Portland Fire Department
Fire Prevention Bureau
380 Congress St
Portland, ME 04101

July 16, 2015

This letter is to confirm we have accepted your Plan of Action for the property located on 86 Quebec St. Please call us at (207)-874-8400 to keep us up to date if anything should change with this plan. We have scheduled an inspection for September 1, 2015 at 10am to follow up on the following violations:

Existing 2nd Flr. Hall/stair

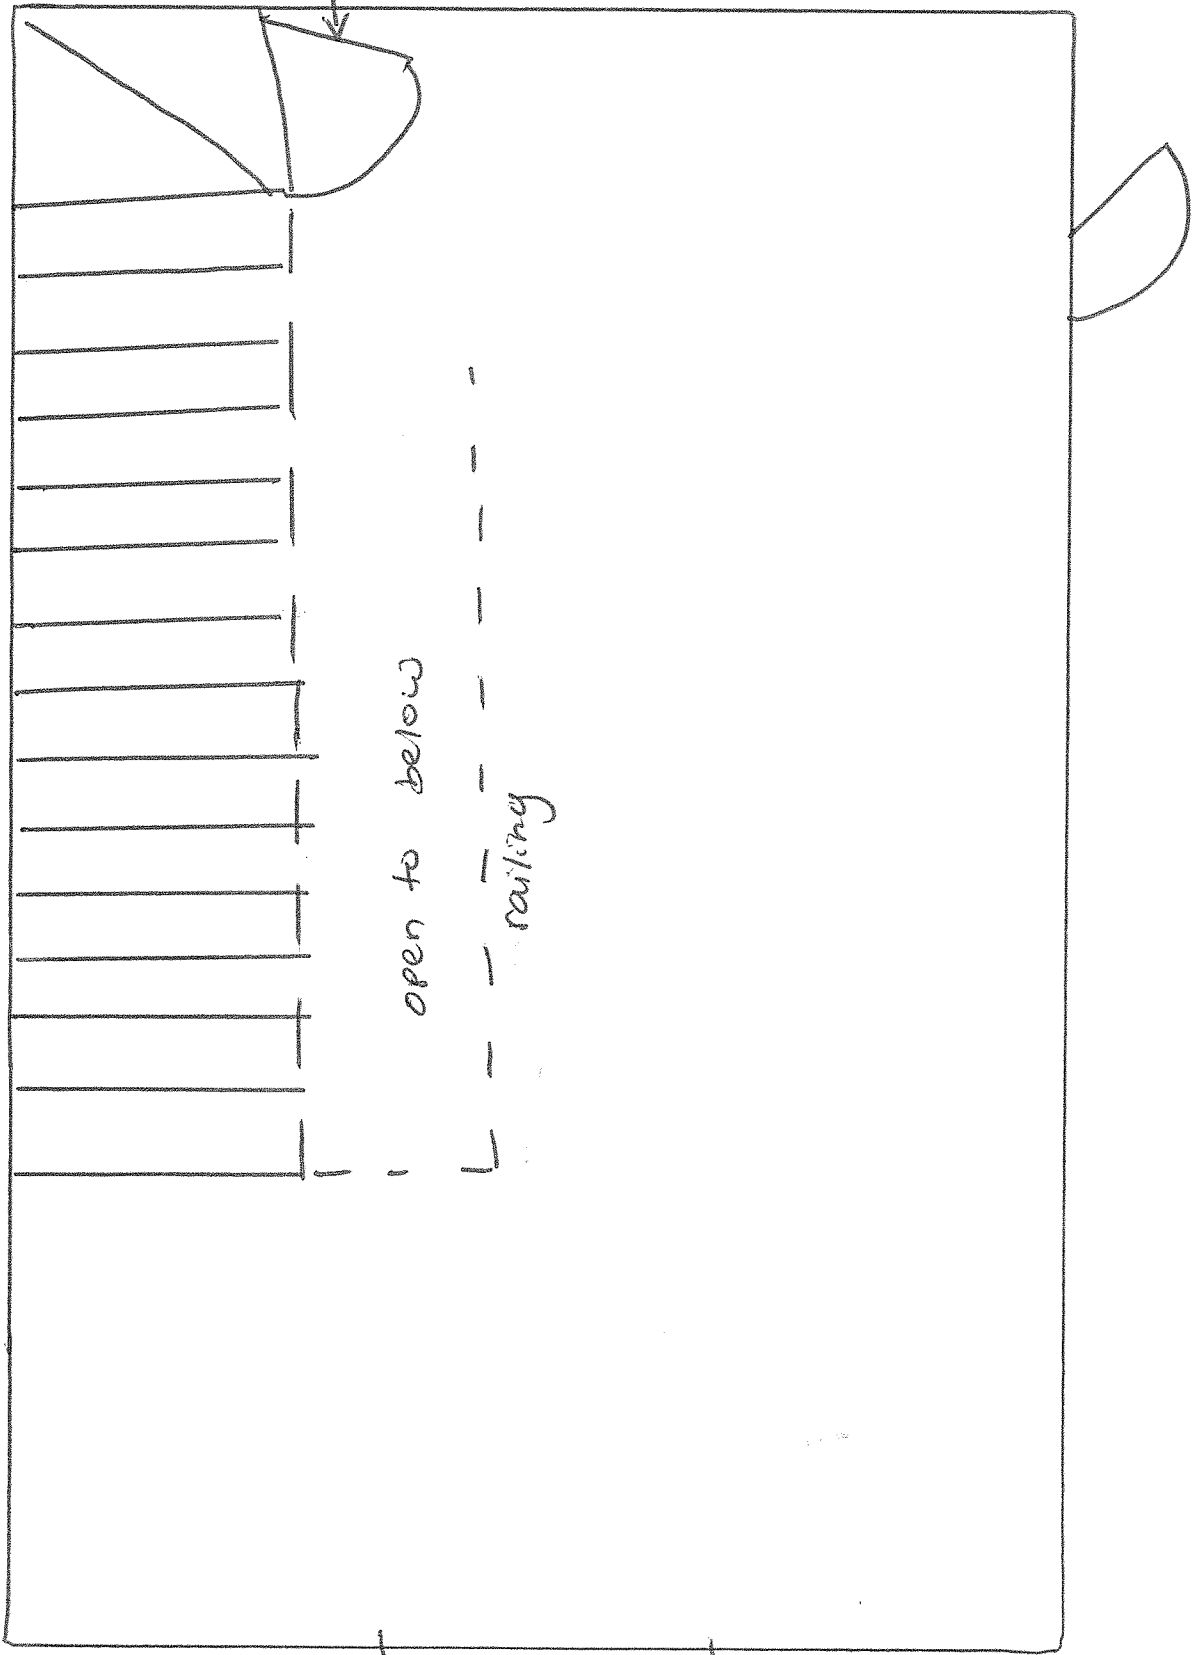
- All doors shall be replaced with fire rated doors.
- Third floor entry to second floor will be moved to be less than 35 feet from the front entrance to eliminate the need for third floor second means of egress.
- Sprinkler heads will be installed over the gas water heaters in the basement.
